Re: 1st Site Development Plan Review, King Soopers #147 – Falcon Market Place

Please find below our re-submittal package addressing the comments received on November 20, 2019. To facilitate your review, we have included the original comments in italicized font, and have provided our responses in **bold**.

GRADING AND EROSION CONTROL PLAN

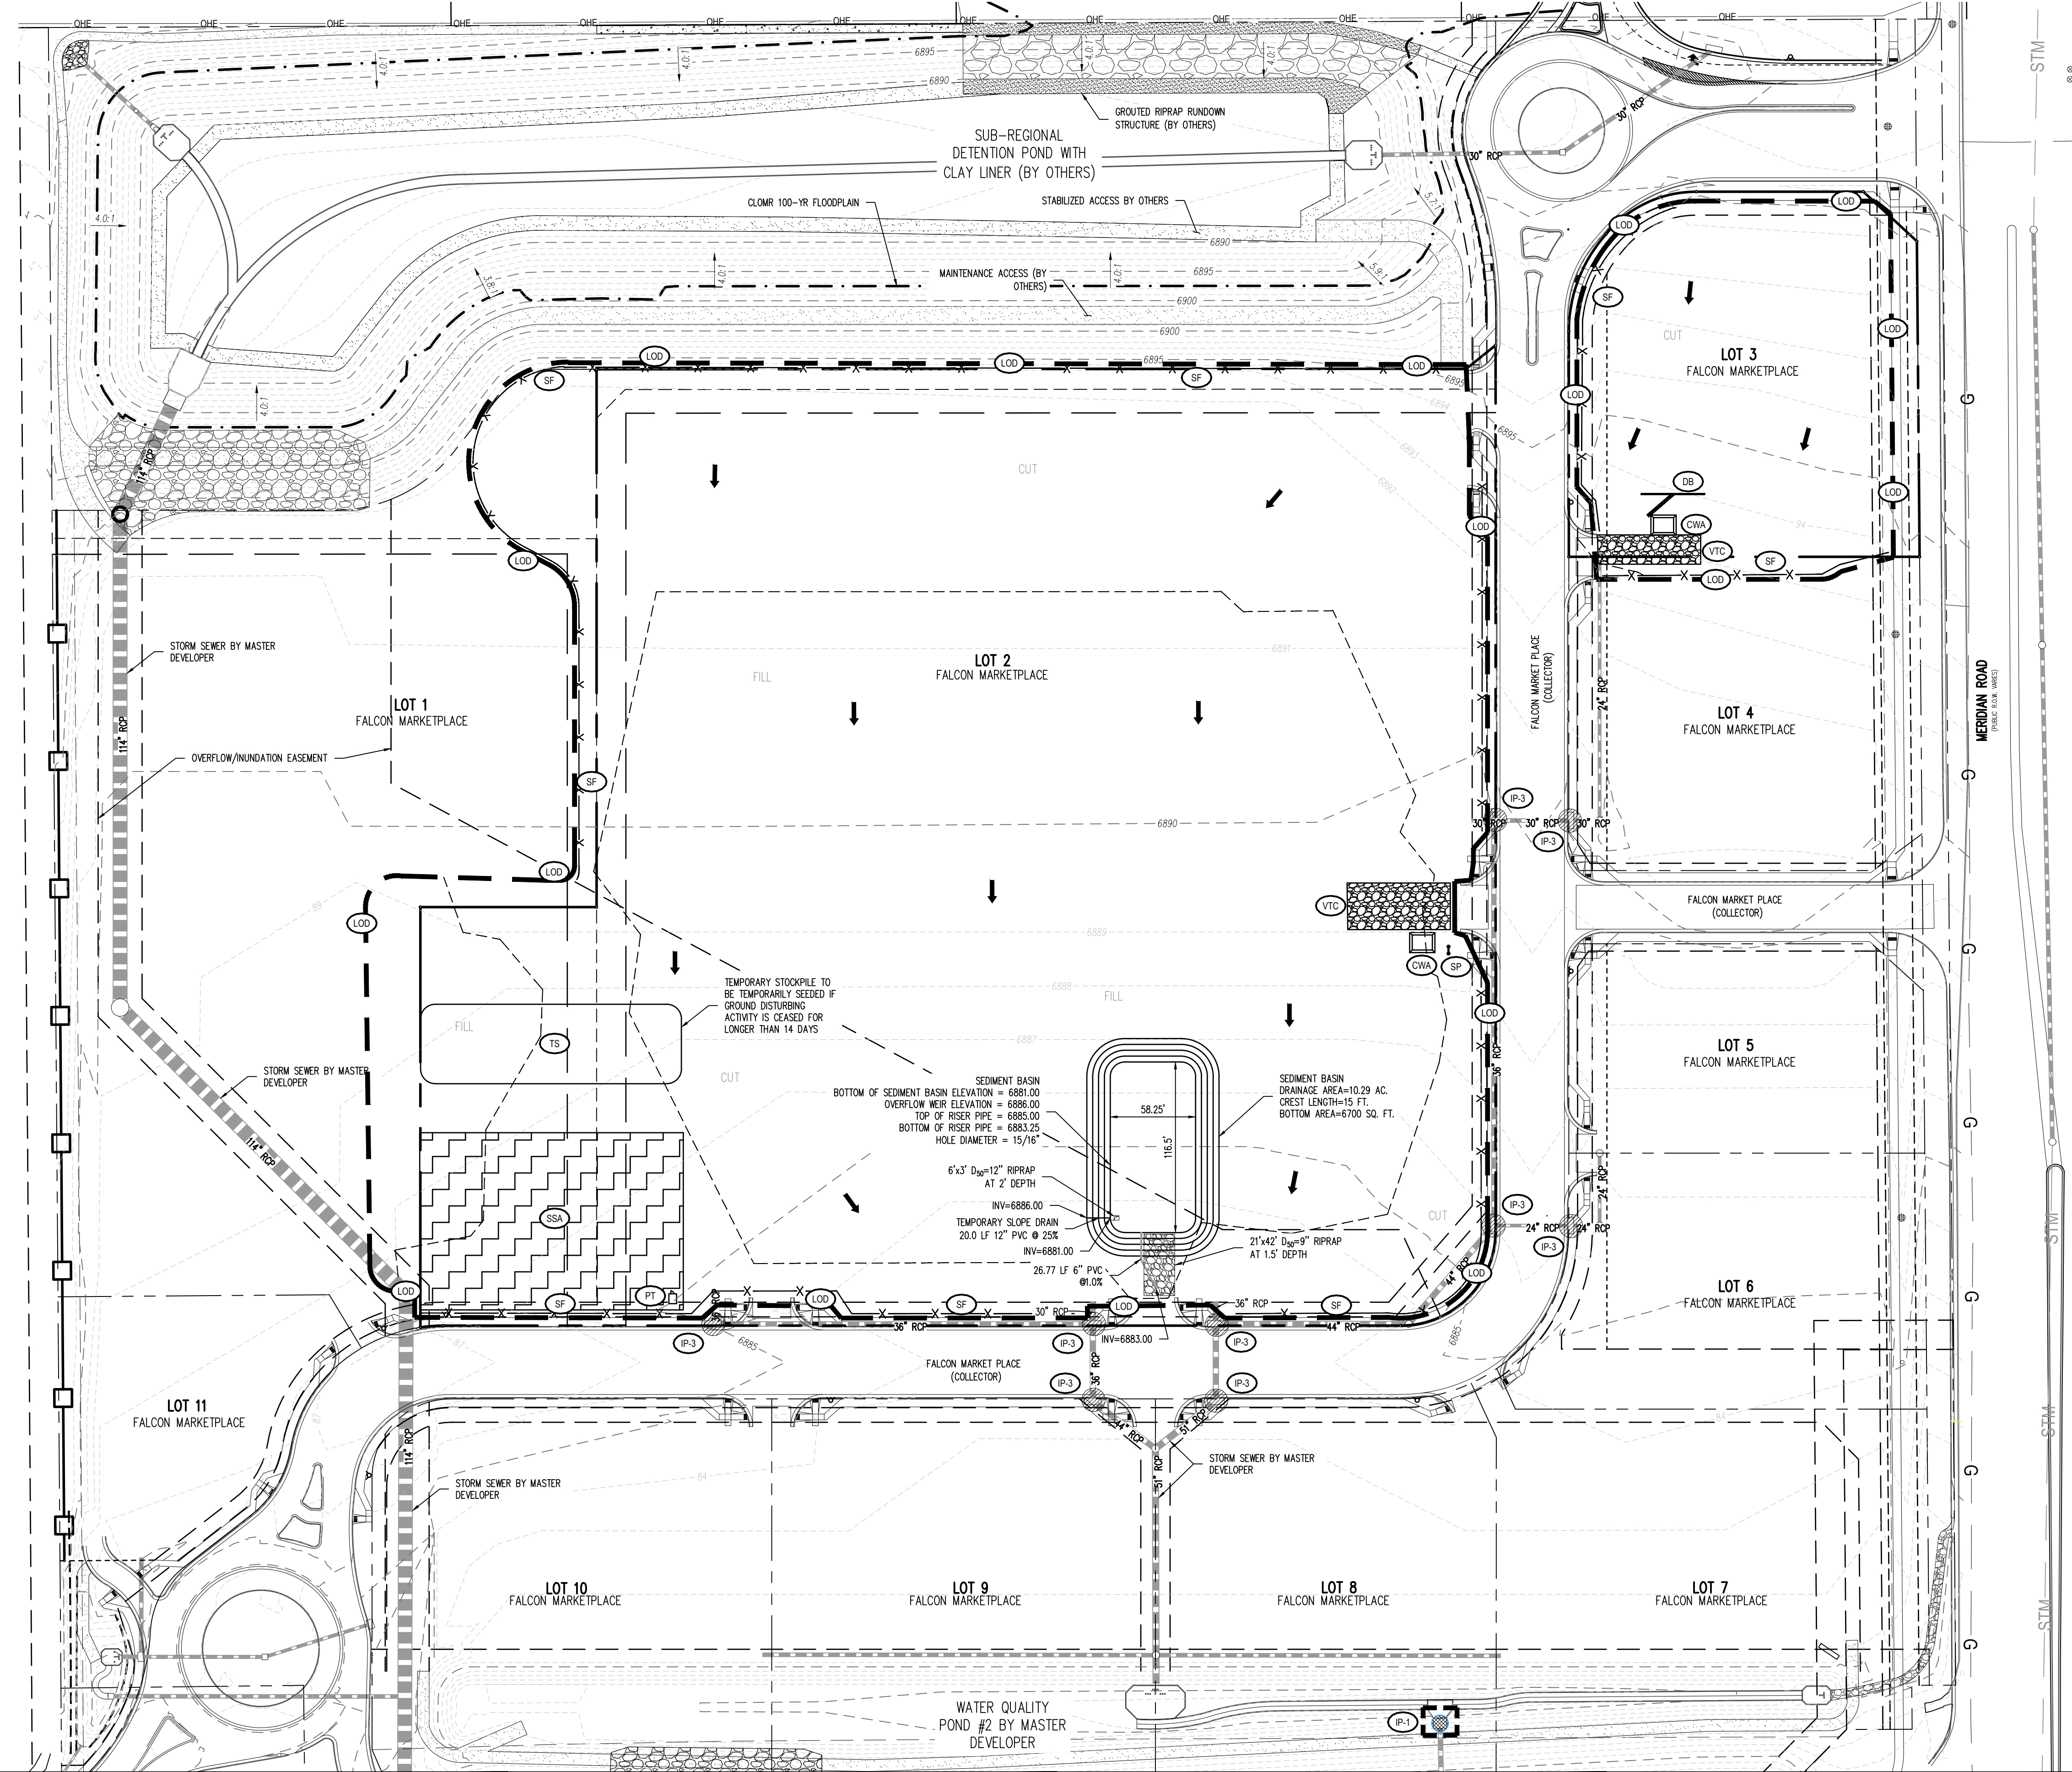
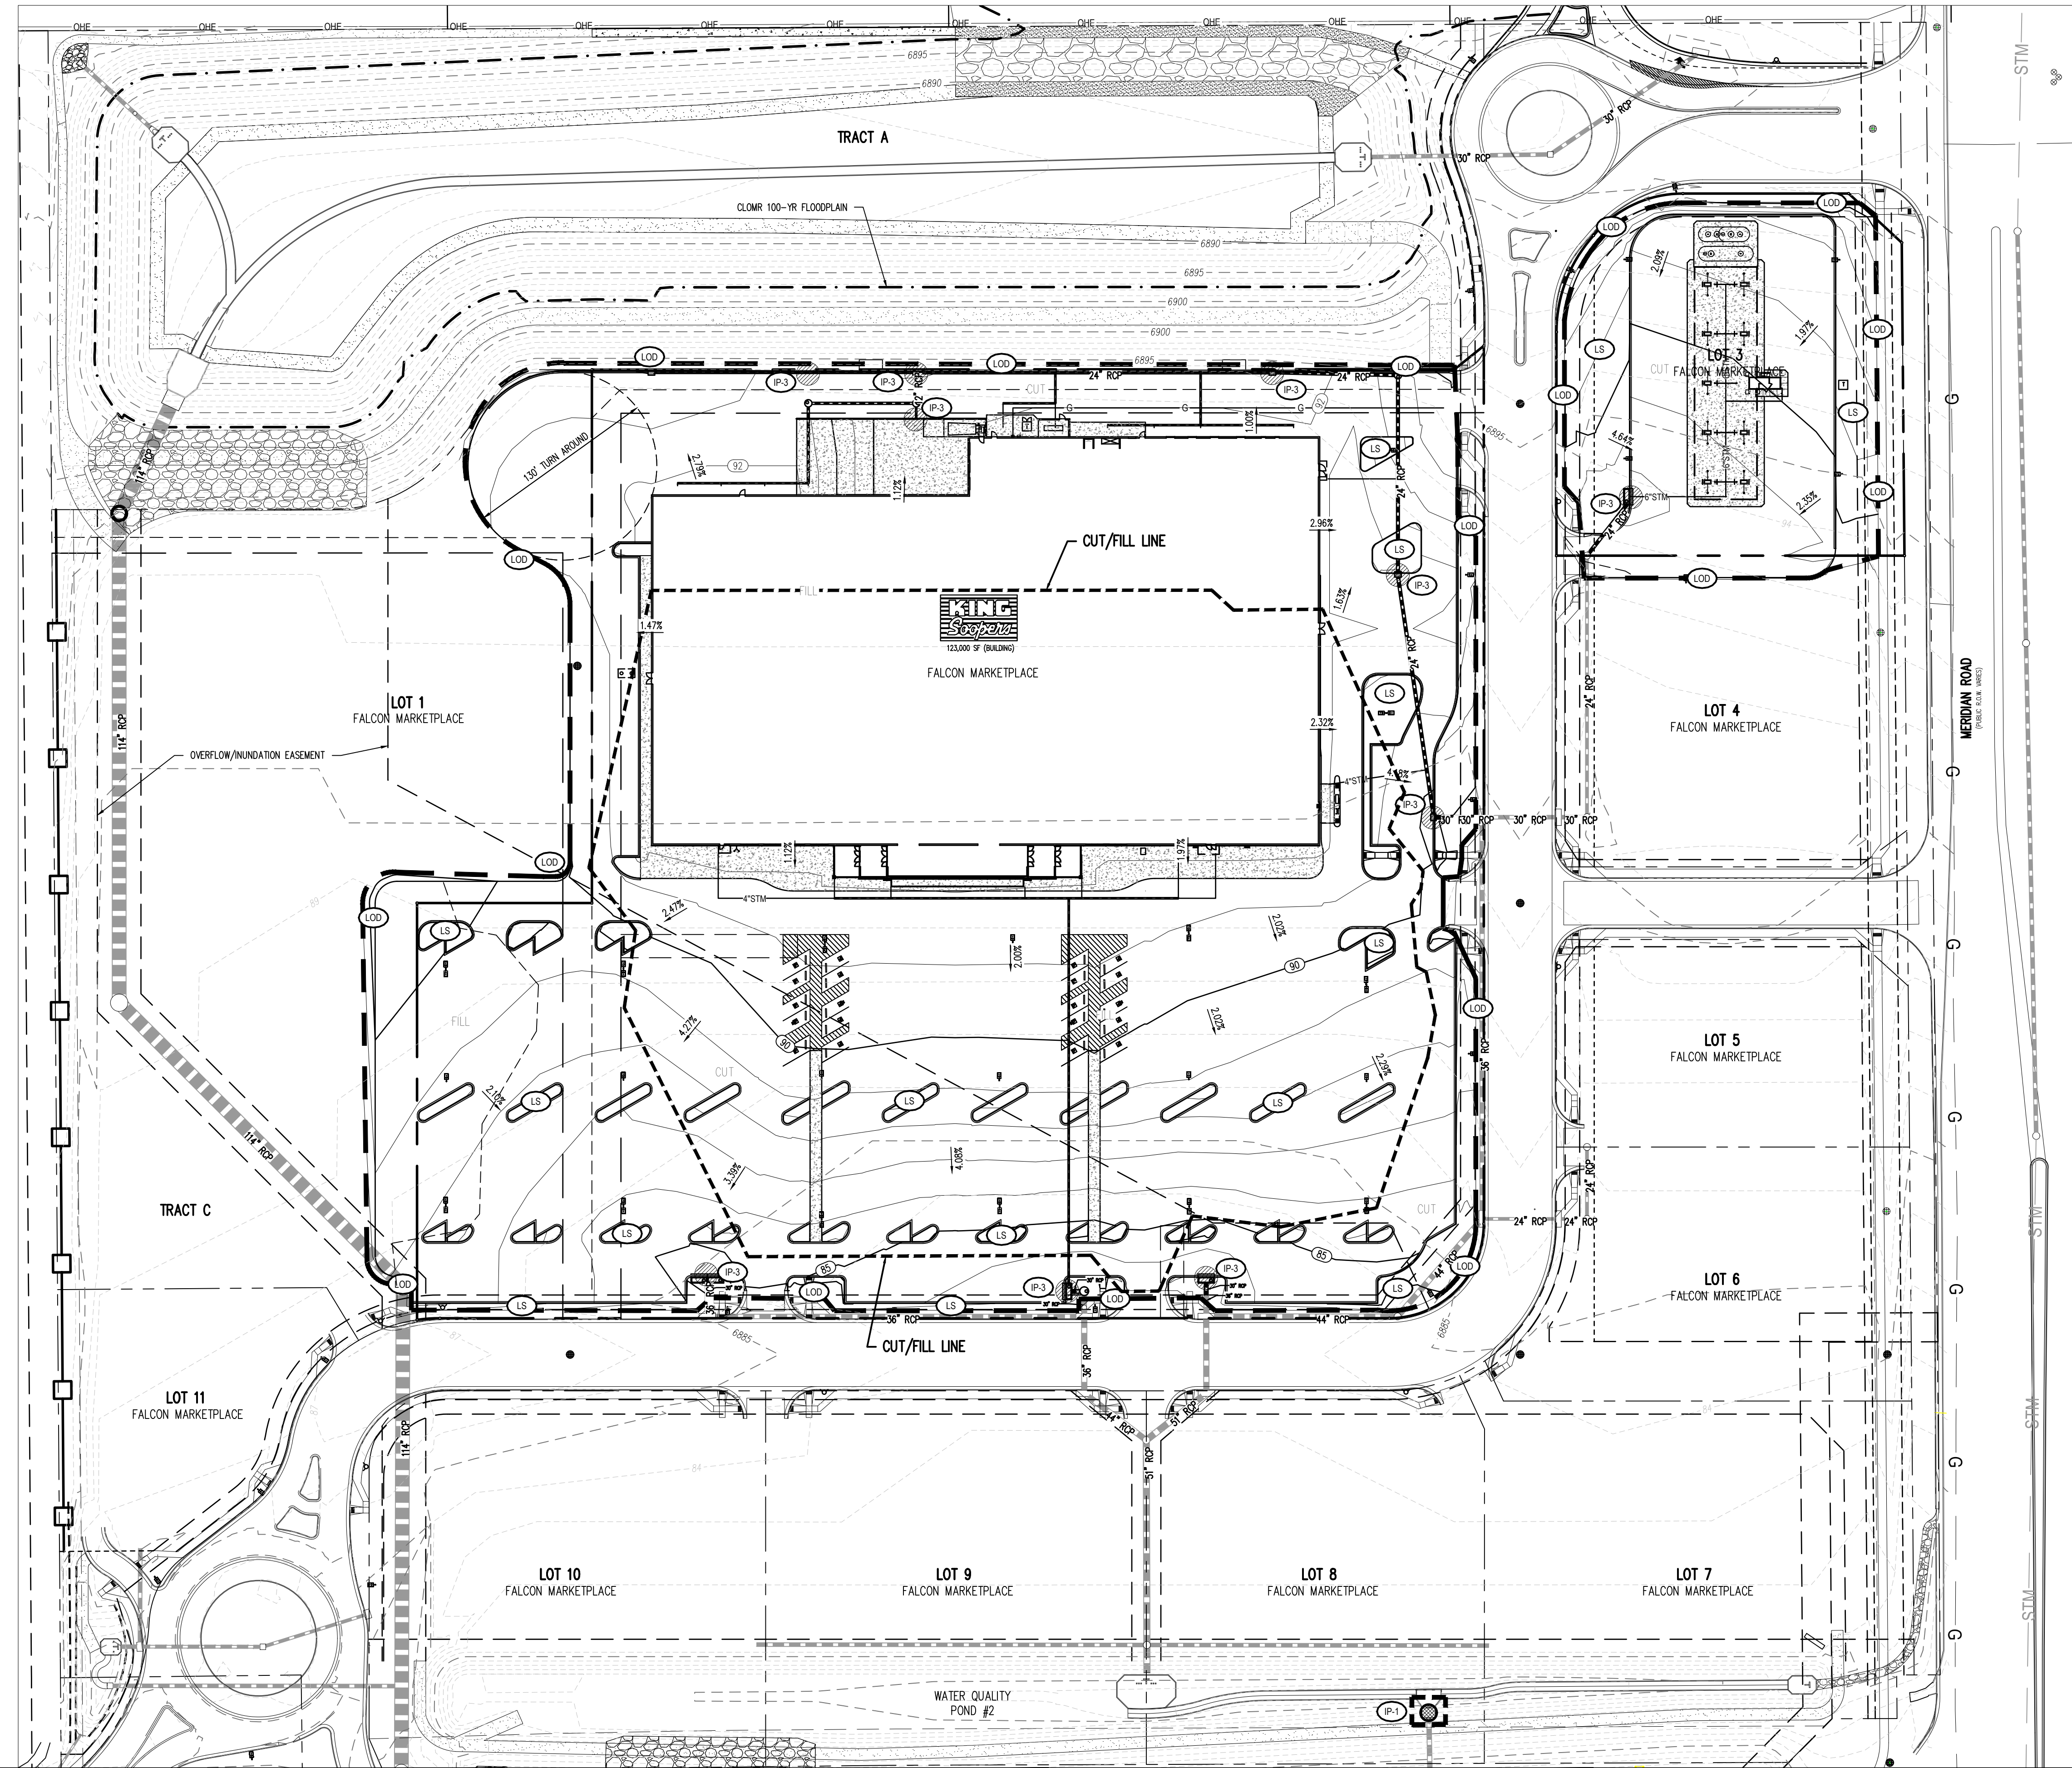
3. **The Grading and Erosion control plan needs to meet the requirements of the new updates, See redline comments on the plan.**

Galloway Response: Redlines have been addressed.

1 CART CORRAL DETAIL
NOT TO SCALE

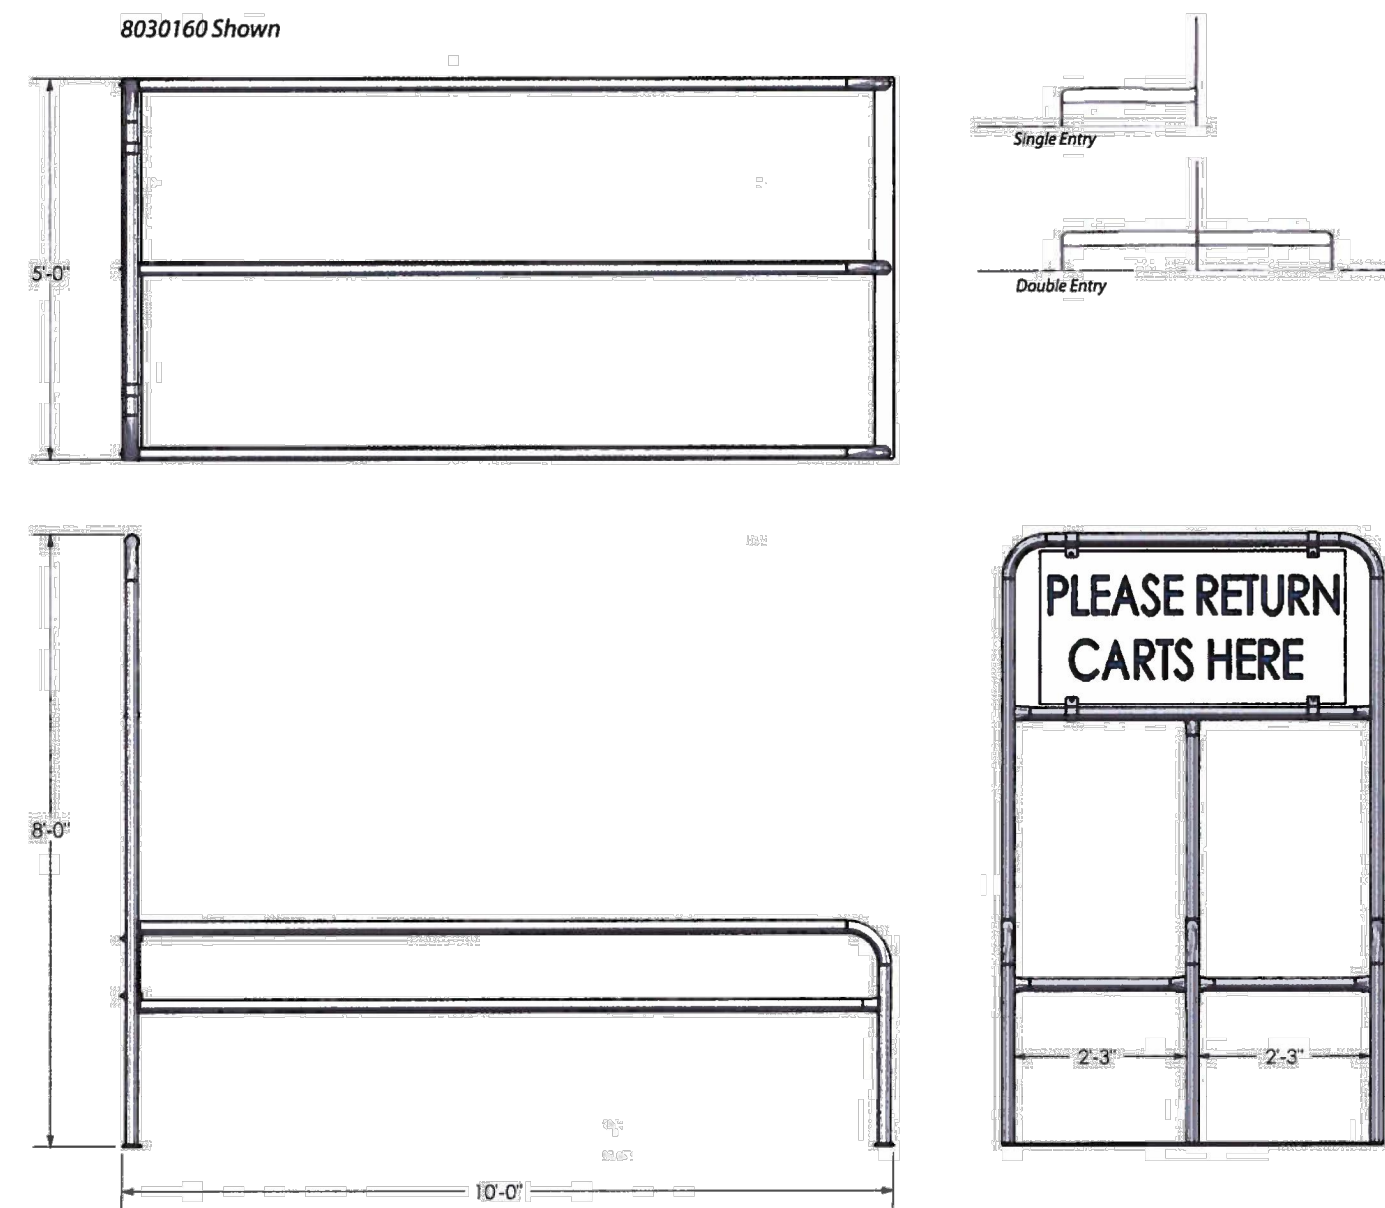
✓ label parking spaces with CC sheet 2 and provide cart corral detail on sheet 3- remove circles with number

Galloway Response: Bicycle parking has been updated in table and on plans.
